Ref: EP/2/21HH

Description of works: Erection of front extension to create first floor balcony, following demolition of existing conservatory with changes to external materials and wall finishes,

Location: 27A Sea Lane, East Preston, BN16 1NH

Rear Elevation (east)

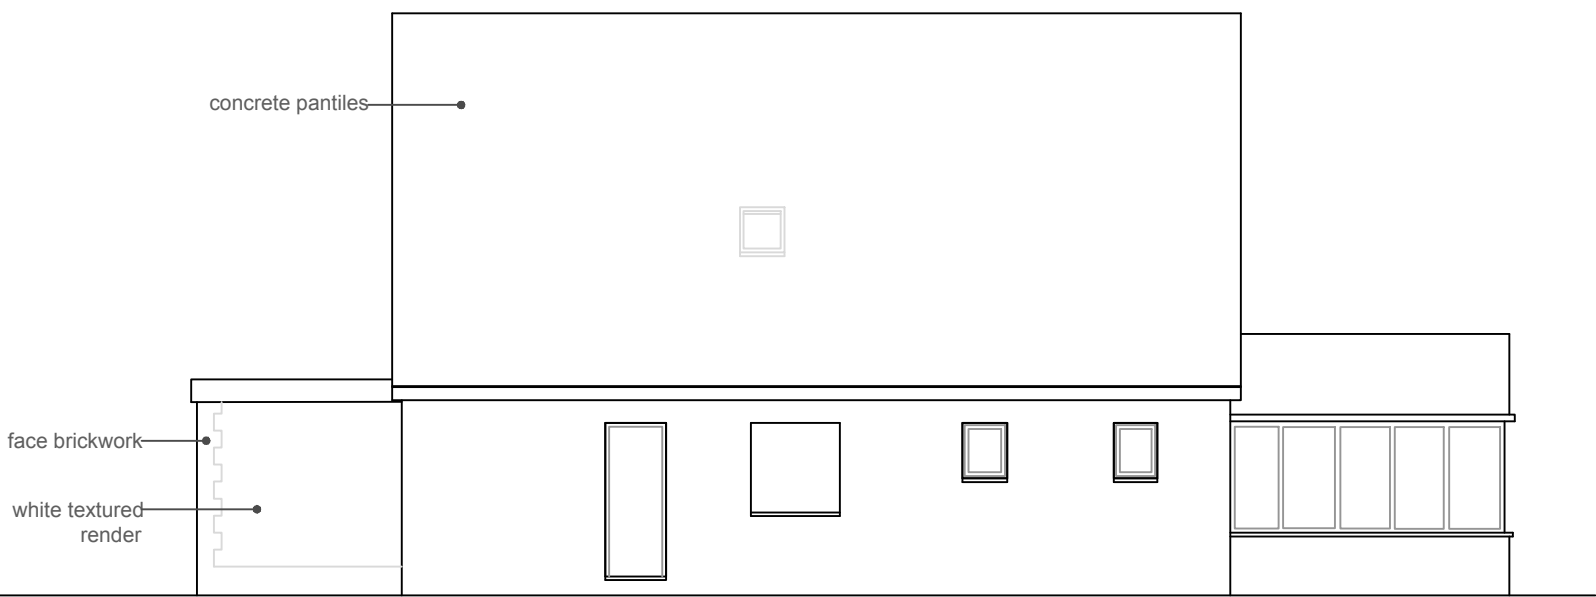
1, First Floor Balcony (to the rear of 27A)

We object to the rear balcony on the following grounds:-

It is not a permitted development and will need planning permission. The rear balcony proposed is not mentioned in the description of works and I quote.

Erection of front extension to create first floor balcony, following demolition of existing conservatory. no mention of a rear balcony! However, the balcony is clearly shown on the plans.

Our main objection is one of loss of privacy as, if this balcony application is granted, the new residents, standing on this new recreational space/balcony, will look directly into the gardens, living rooms and kitchens of numbers 8 and 9 Oakley Gardens. Plus into the house and annex of number 27 Sea Lane. Also into the gardens of other properties in Sea Lane and Normandy Drive.

There is no precedent for first floor balconies at the rear of houses in the area due to the proximity of other properties in the area. Therefore rear balconies, overlooking neighbours gardens and living areas, are not suitable.

Thank you for considering our objections to this application. We hope that we have clearly outlined the reasons for our objections. Our main concern is for loss of privacy due to the proposed balcony to the east side of the house. We are happy for council officers to visit, if necessary, to satisfy themselves the our objections are valid.
